The comments and opinions of the local people – the residents of Bankfield Drive, Laithe Avenue the surrounding area – have been continually ignored and over-ruled by Kirklees Planning Dept and Orion Homes. The consultations have merely paid lip service to the process.

There has been an astounding 149 objections so far to this application since Orion submitted planning permission. Many reports have been produced by Orion to justify building, reports with many inaccuracies and omissions, and many statistics produced based on national averages. But the local people know that cramming 21 houses onto this small exposed plot does not make sense – the report in Agenda item 12 for the Strategic Planning meeting of 5 Dec states:-

PROJECT	CLIENT				
BANKFIELD DRIVE, HOLMBRIDGE	ORION HOMES				
DRAWING TITLE	CHECKED	APPROVED	DRG No.		
	PO	PO	22027/GA/01		
	DRAWN BY:	SCALE @ A2	DATE	REV.	
DOBB TOP ROAD/ BANKFIELD DRIVE PROPOSED IMPROVEMENTS	SG	1:200	NOVEMBER 2023	D

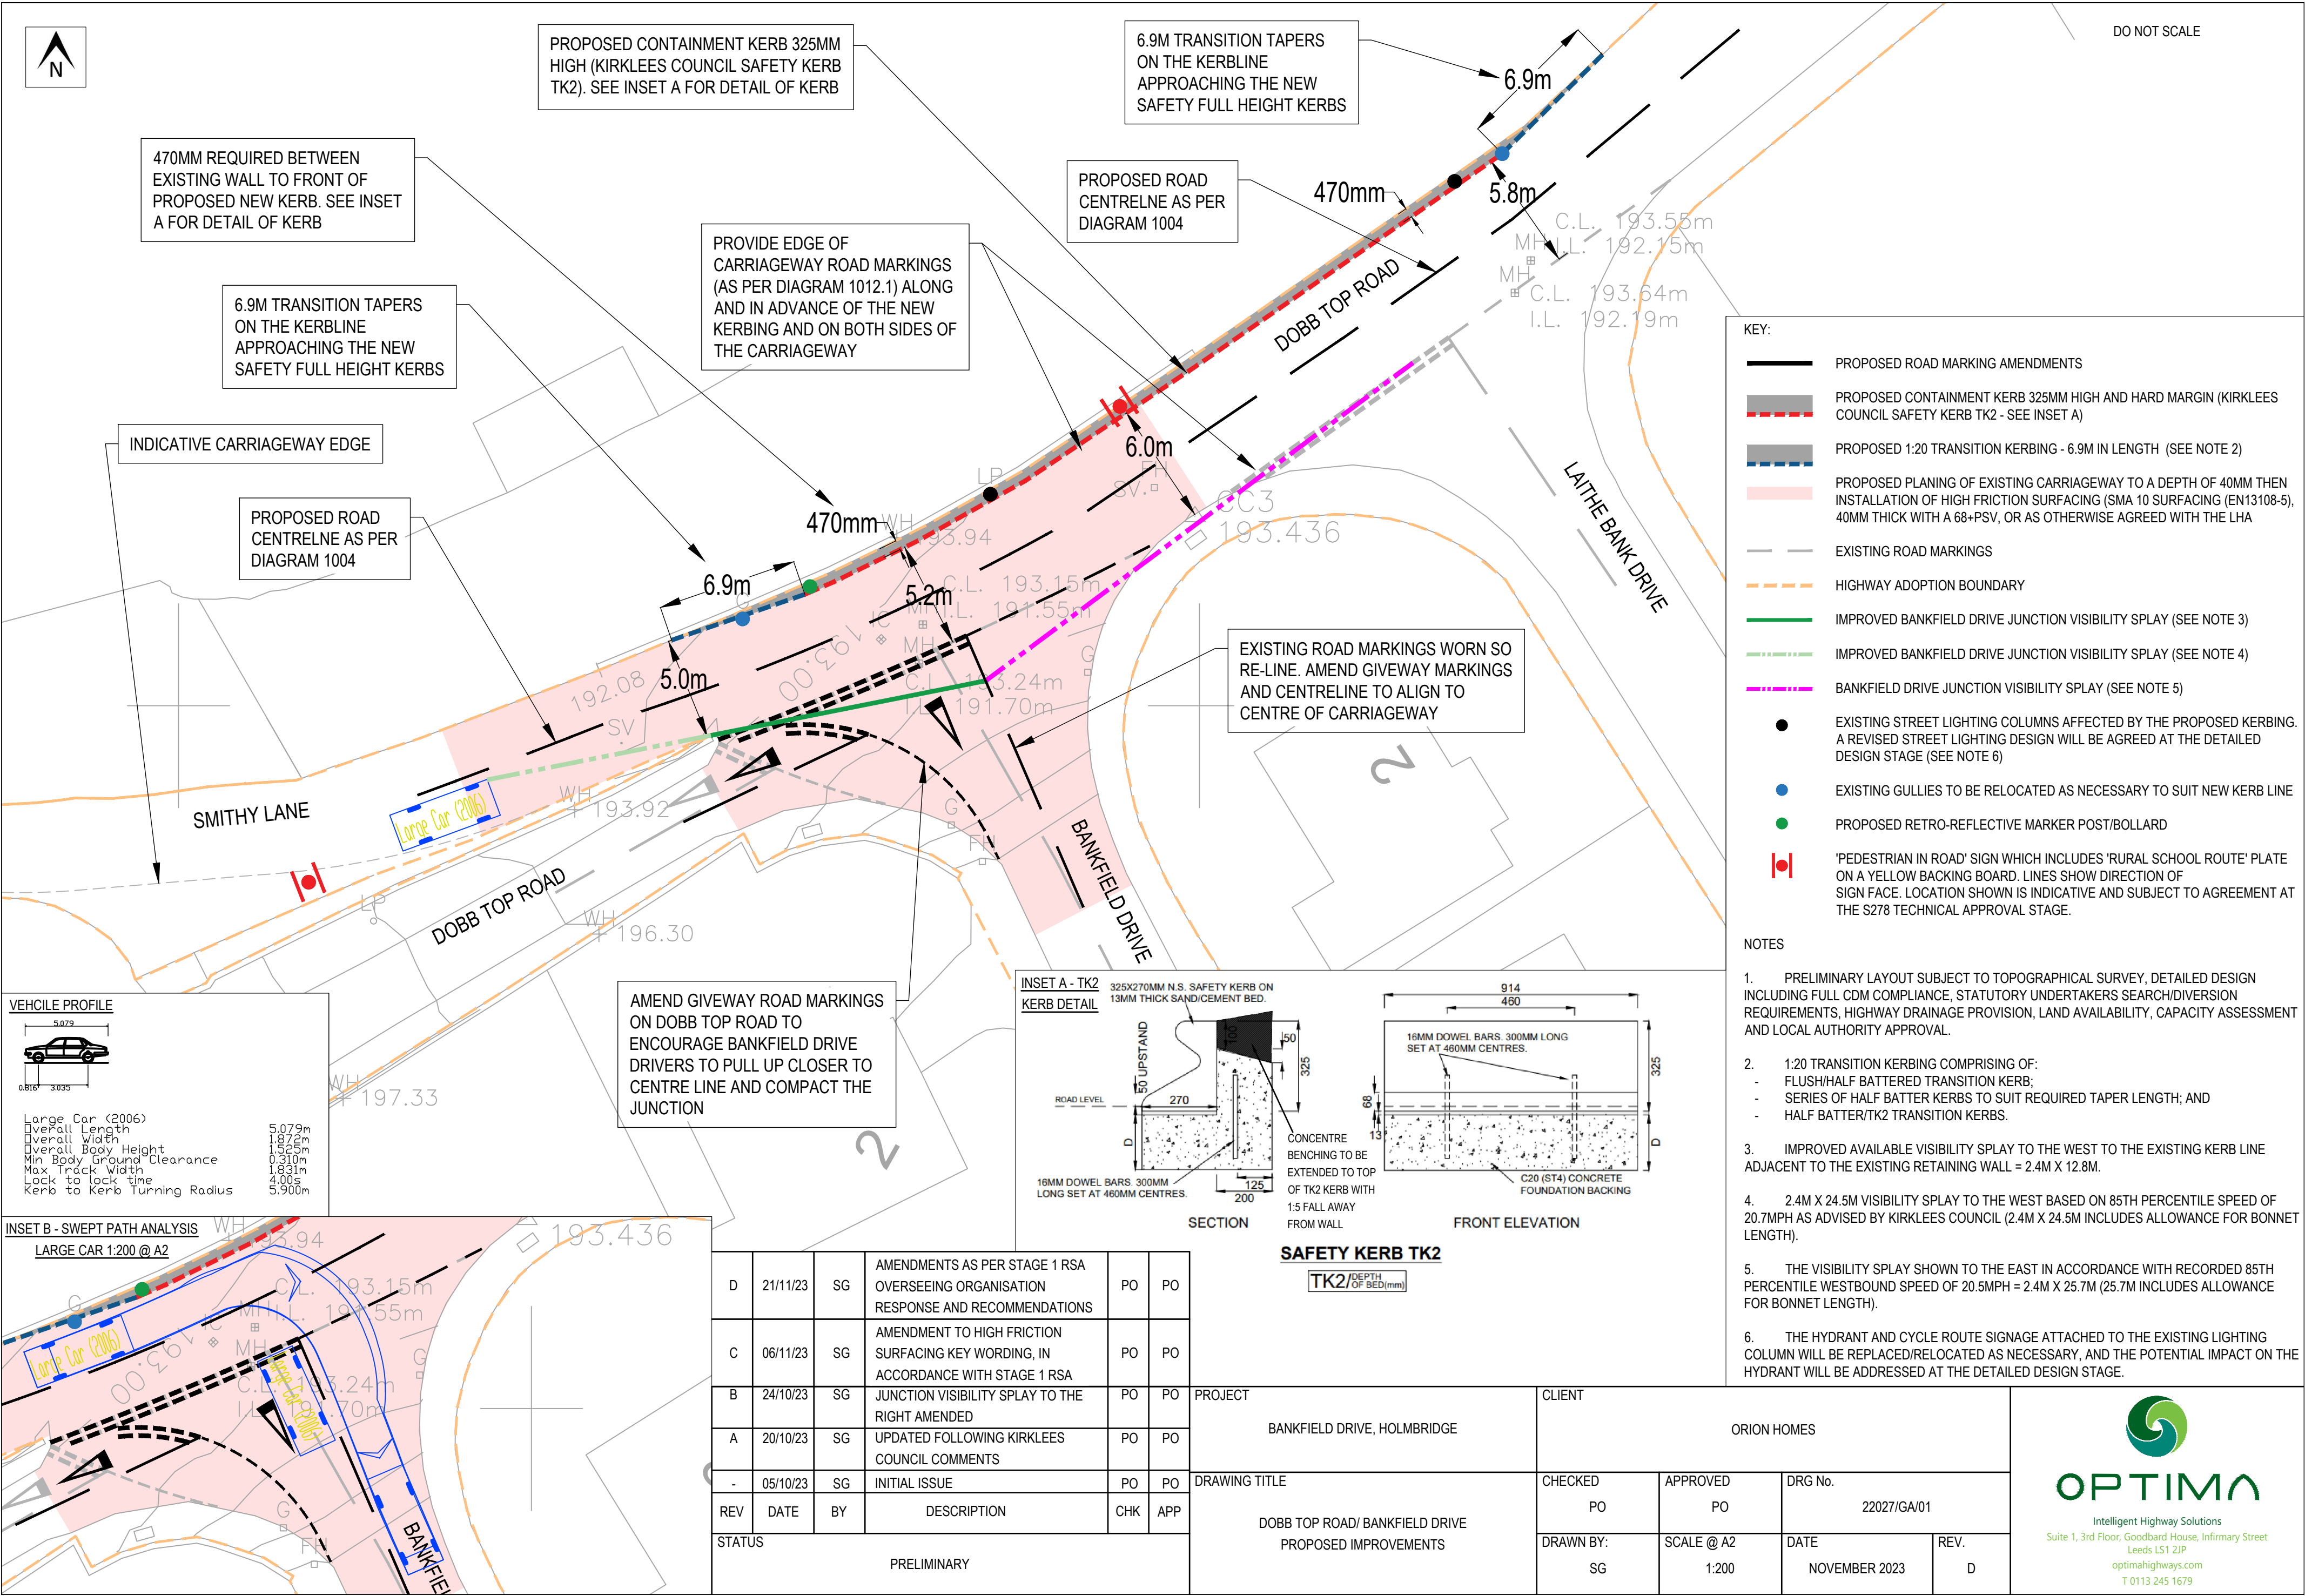
Locals know that the steep roads leading to the site are dangerous in inclement weather and that the frequency of ice and snow is higher here. Kirklees admit that the anti-skid surface would have limited impact in snow/ice conditions (10.99 Agenda item 12)

We know that a few more signs will not change how vulnerable pedestrians are as they have to walk in the centre of Smithy Lane past parked cars and along Dobb top Road with no pavements.

TITLE
S104 DRAINAGE LAYOUT PLAN

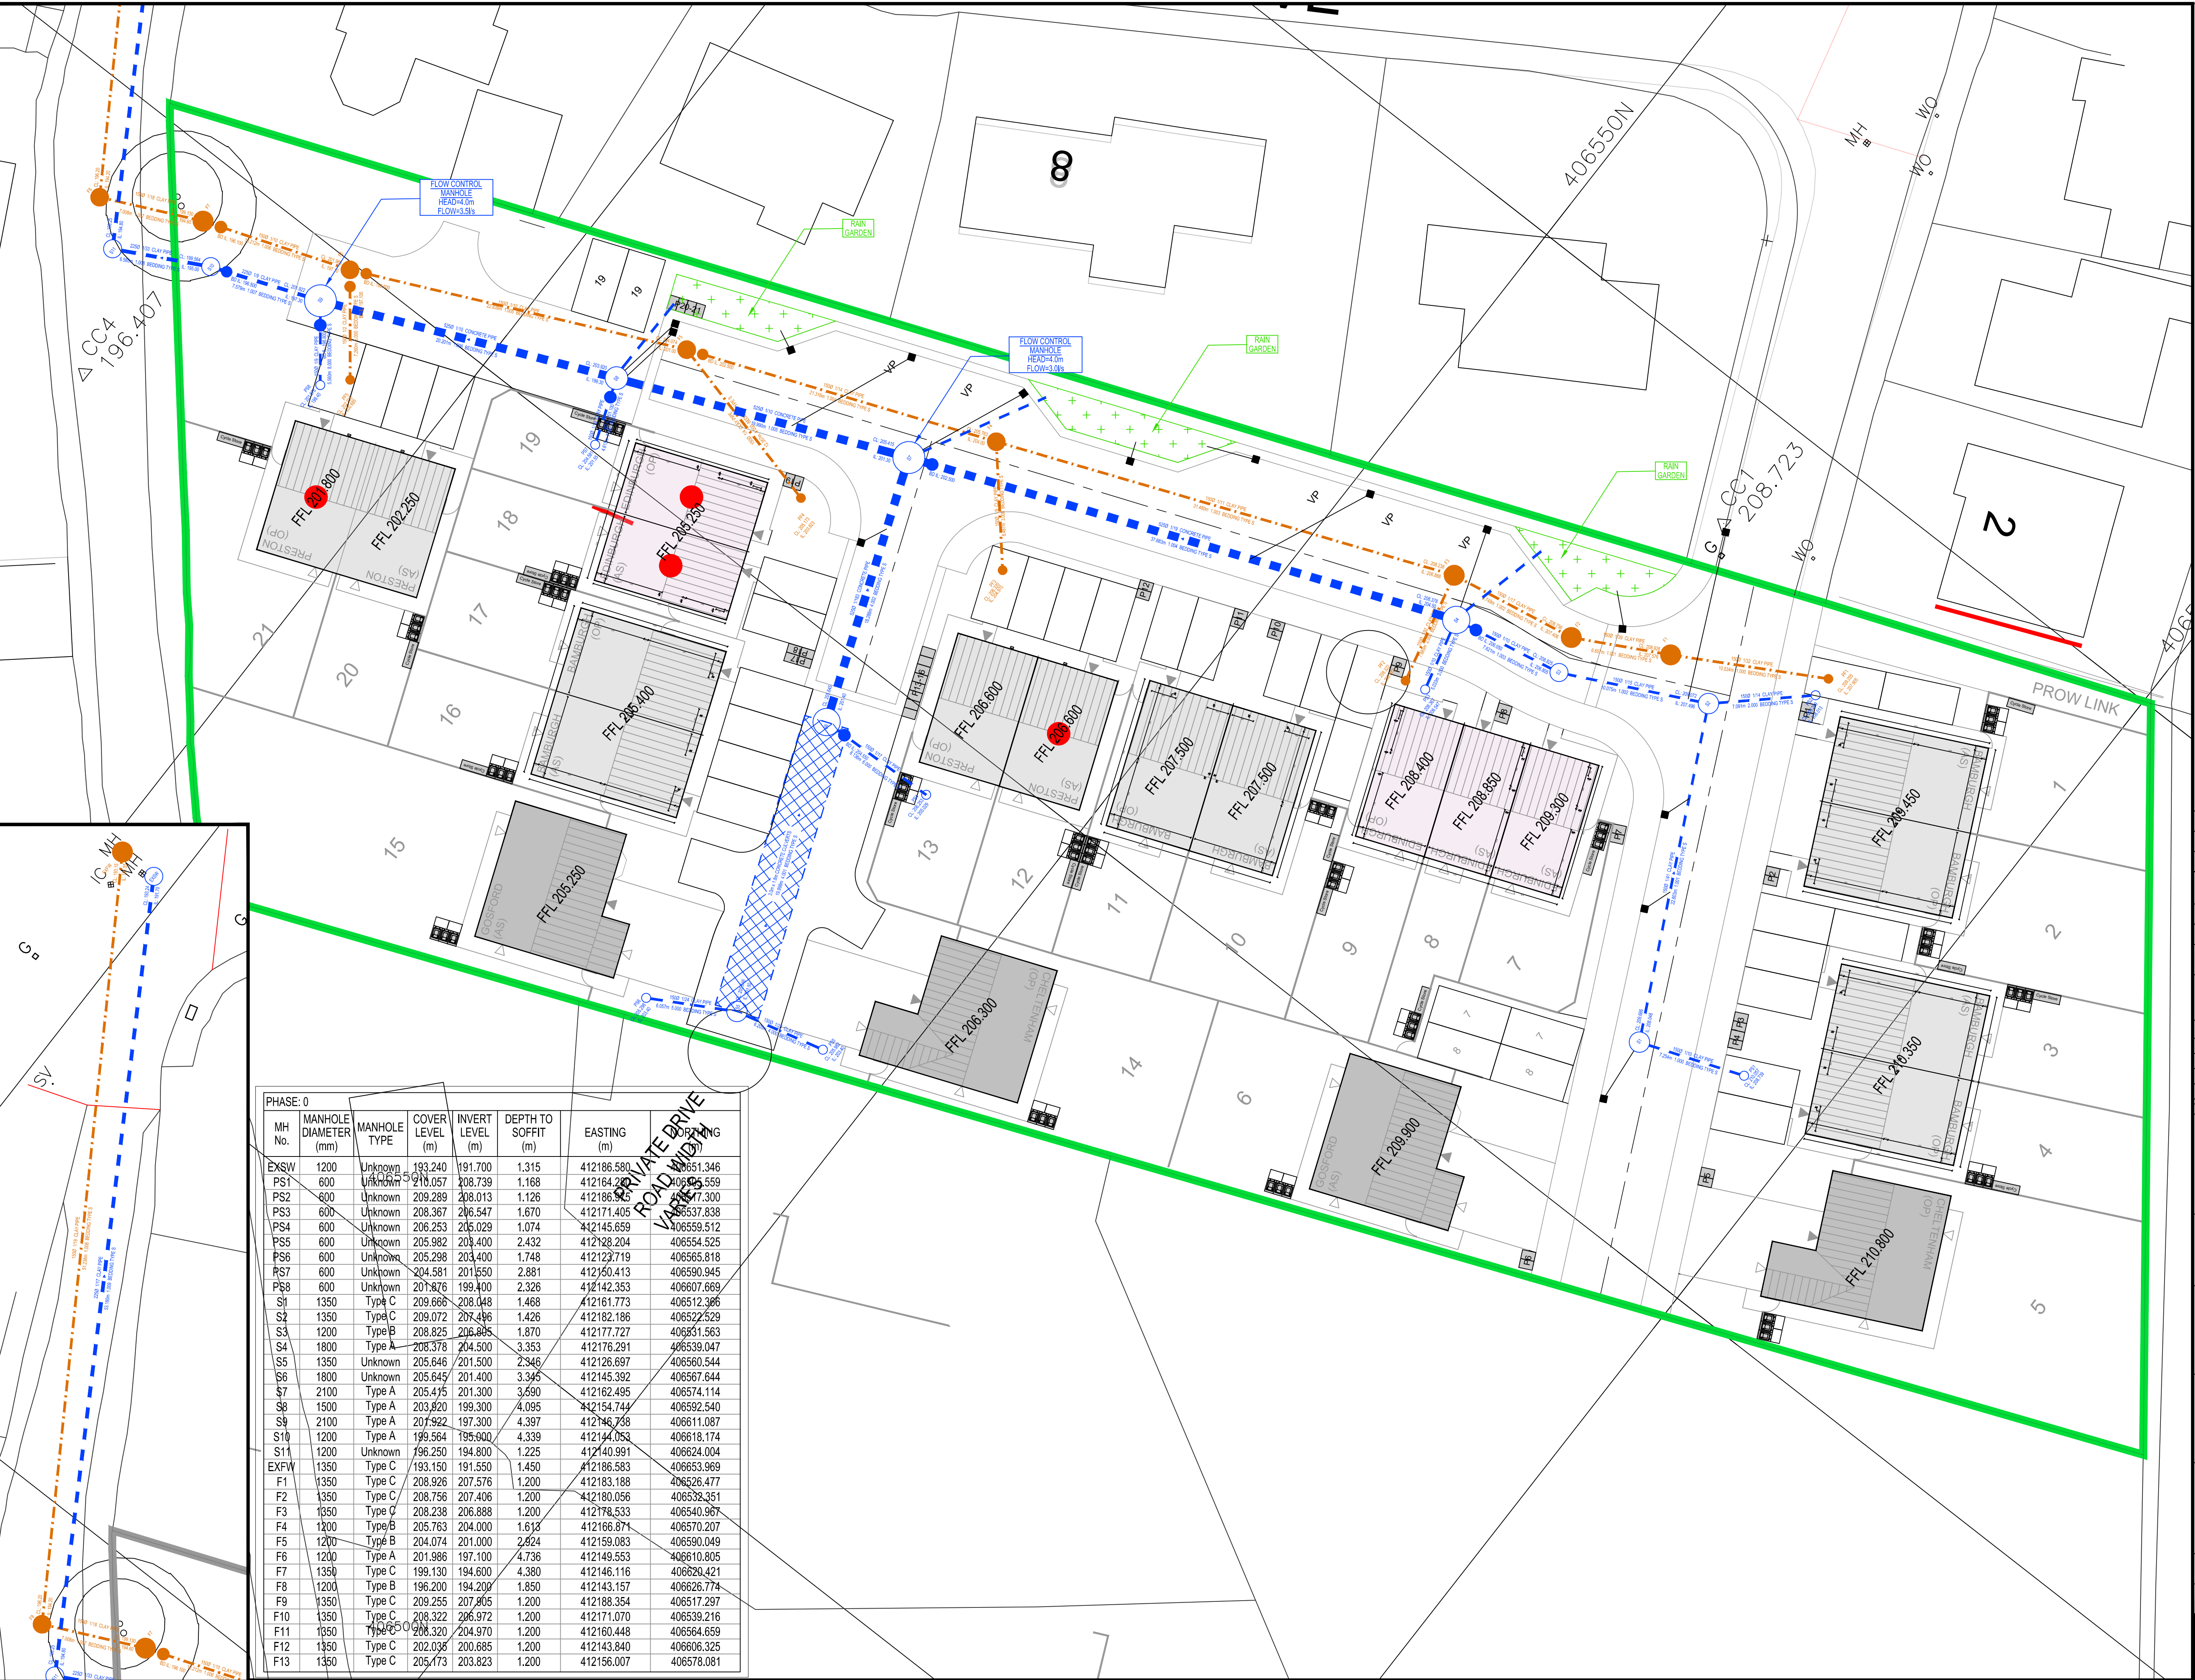
We know that increased demand on the ancient sewerage system from the new houses onto Dobb Top Road will only increase the incidence of the already regular sewerage leaks onto Bank Lane, which then leeches into the River Holme. That there is subsidence on Dobb Top Road, that a wall has already collapsed just along from the Northern boundary of the site. That there are signs of collapse of the road on Laithe Bank Drive, making a depression difficult to drive over.
